***MODIFICATION REQUEST:  
Miranda Dental Hospital  
84 – 86 Kiora Road, Miranda***

***MP 11\_0009 MOD 1***

***Modification to the design of the approved dental  
hospital***

**Director-General's  
Environmental Assessment Report  
Section 75W of the  
Environmental Planning and Assessment Act 1979**

EAST & NORTH ELEVATIONS

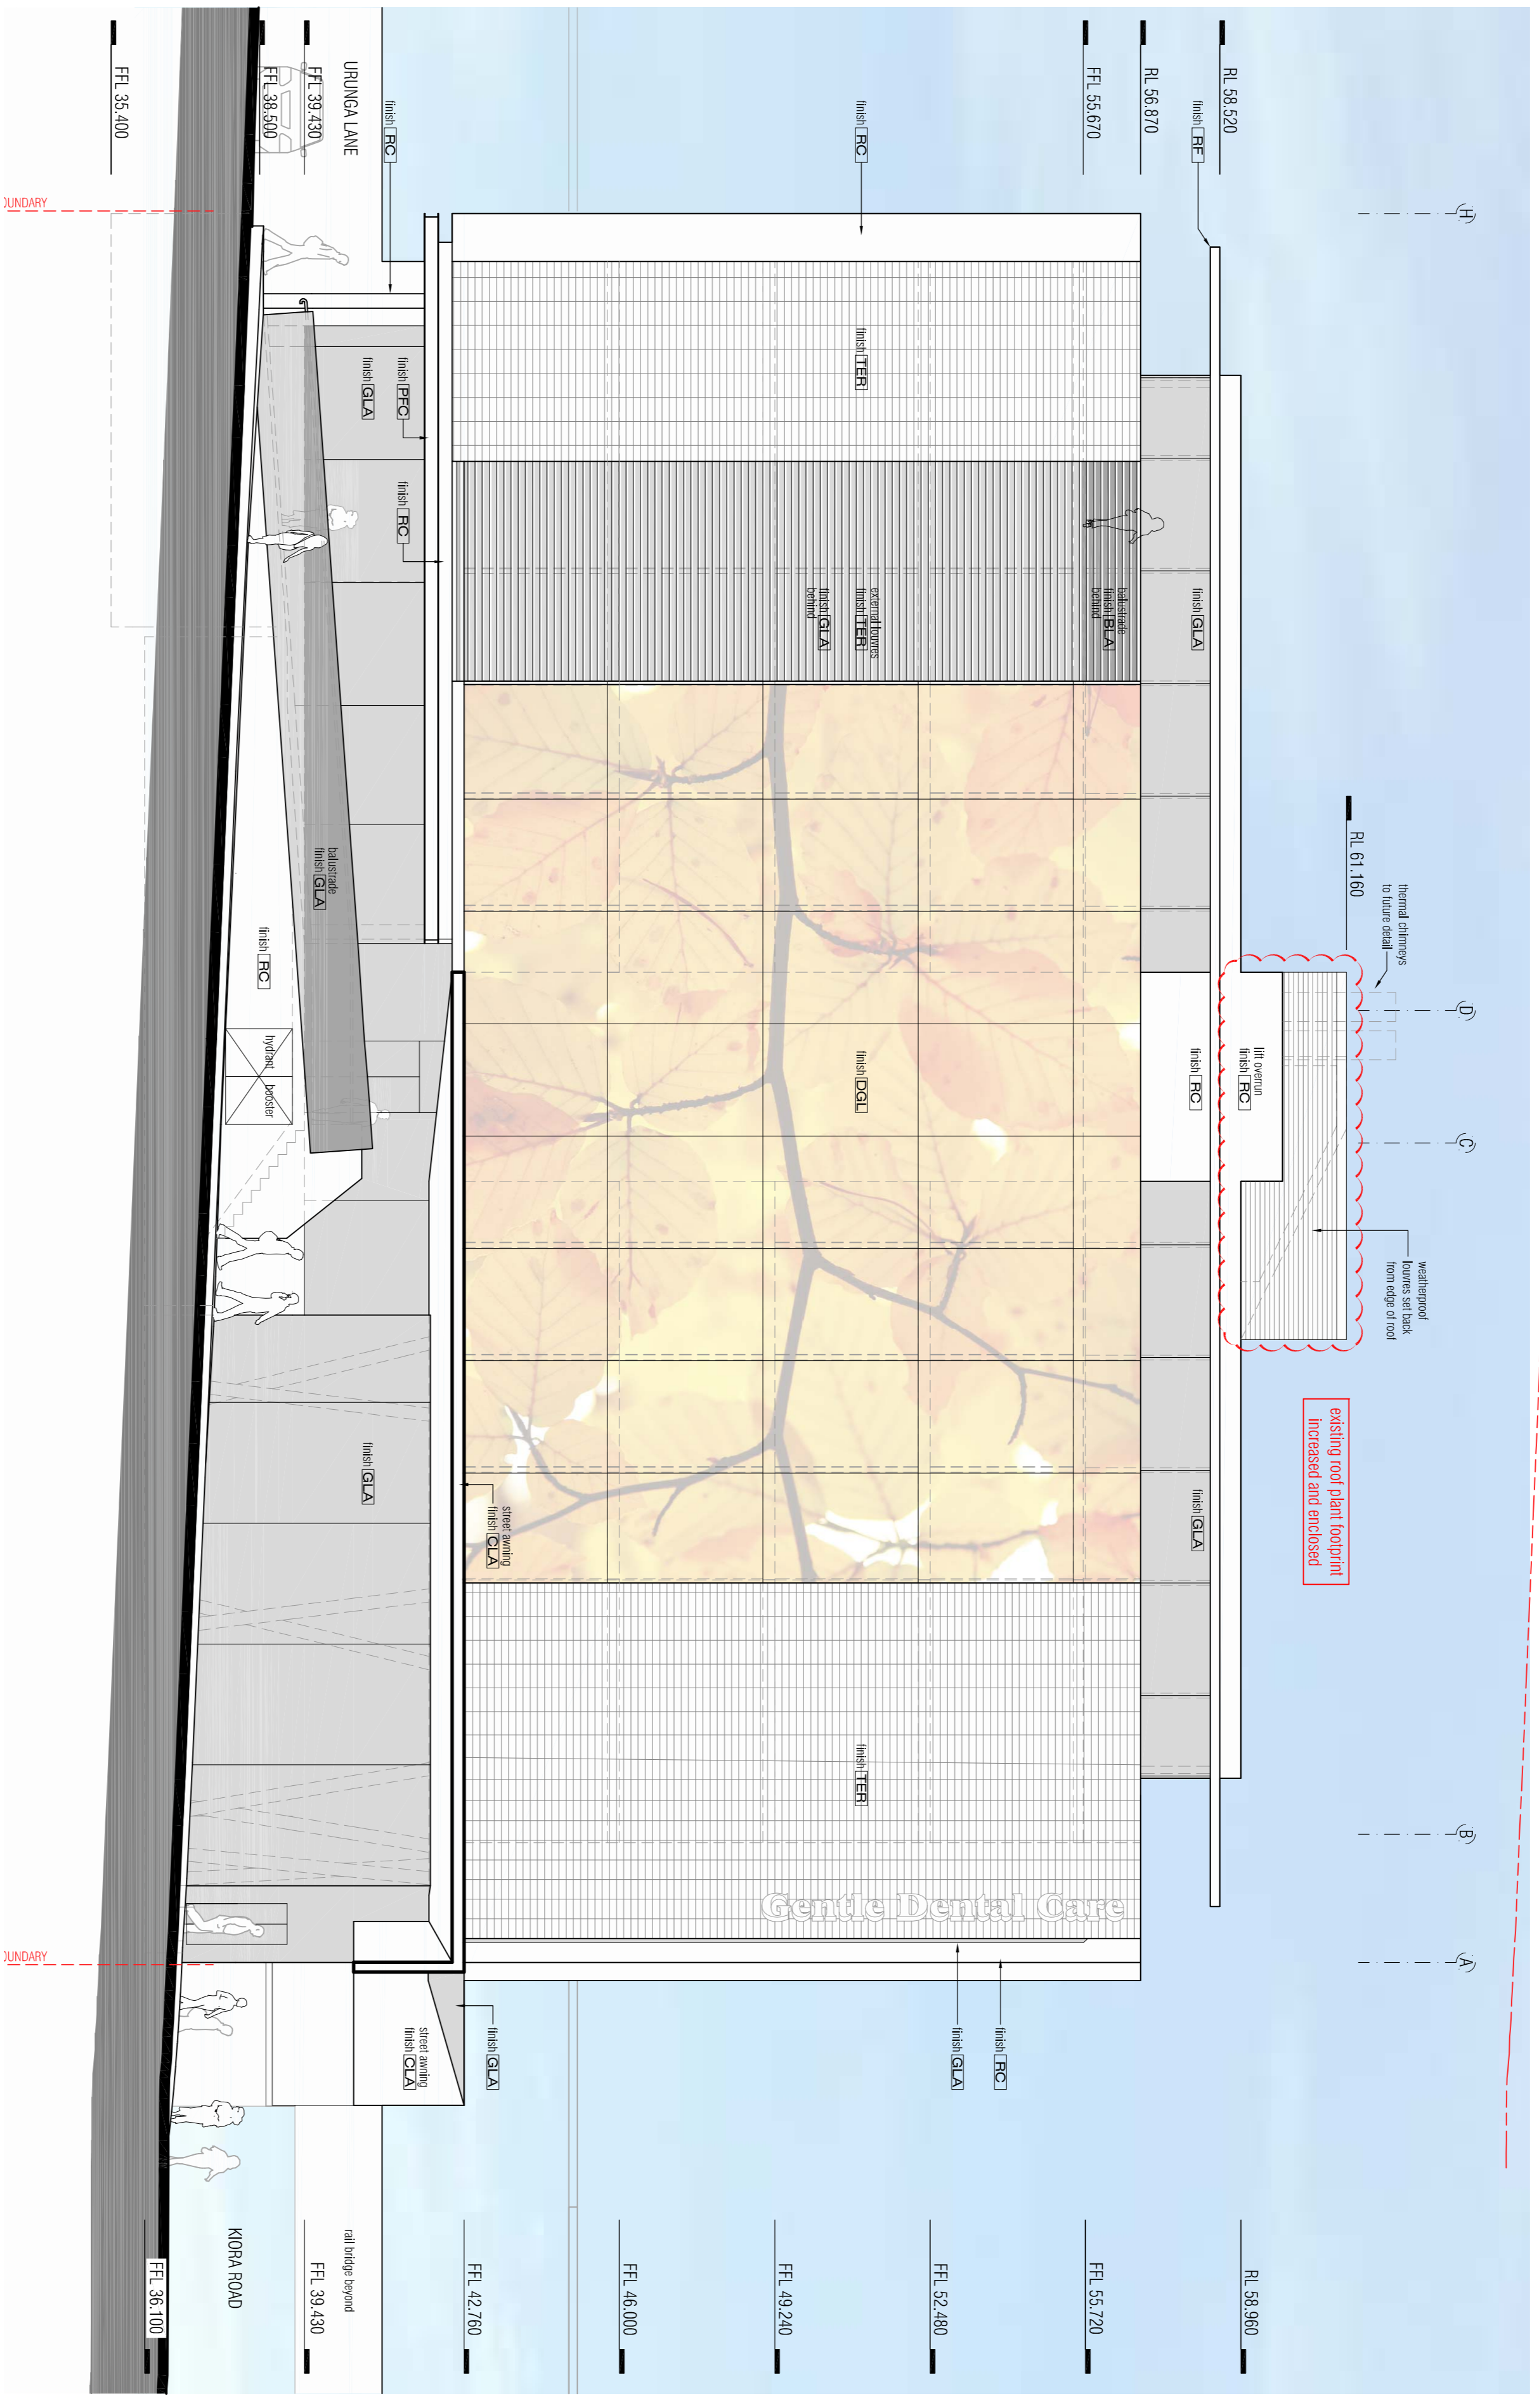
The proposed modification also involves a partial 2.2m height increase to the approved development to accommodate plant equipment relocated from the basement and level 3 of the building. Refer to **Figure 3 and 4**.

Council advised that the roof top will be visible from the vantage points in nearby tall buildings and care should be taken to ensure that the additional height is not unattractive. The proponent advises that the roof top plant will be enclosed with louvers and setback from the edges of the building and would not be generally visible from the public domain. On this basis, the Proponent asserts that the impact of the enclosed plant room will be acceptable.

The Department notes that the footprint of the proposed roof top plant would be centrally positioned and is made up of a mix of masonry and weatherproof louvered screens. The Department is satisfied that the proposed change to the approved plant at the roof level is limited in scope and would not result in adverse visual impacts or significant overshadowing impacts to its surroundings. The additional height of the roof top plant is considered compatible with surrounding building heights and is well below the maximum permitted 28m height limit under the Sutherland Local Environmental Plan 2006 for the site.

On balance, the Department supports the proposed changes to the built form of the building given that the additional bulk will not be readily discernable from the street or from neighbouring taller buildings. Further, the Department is satisfied that the proposed roof top plant would retain a design standard commensurate with its approved contemporary design. On this basis, the changes are supported.
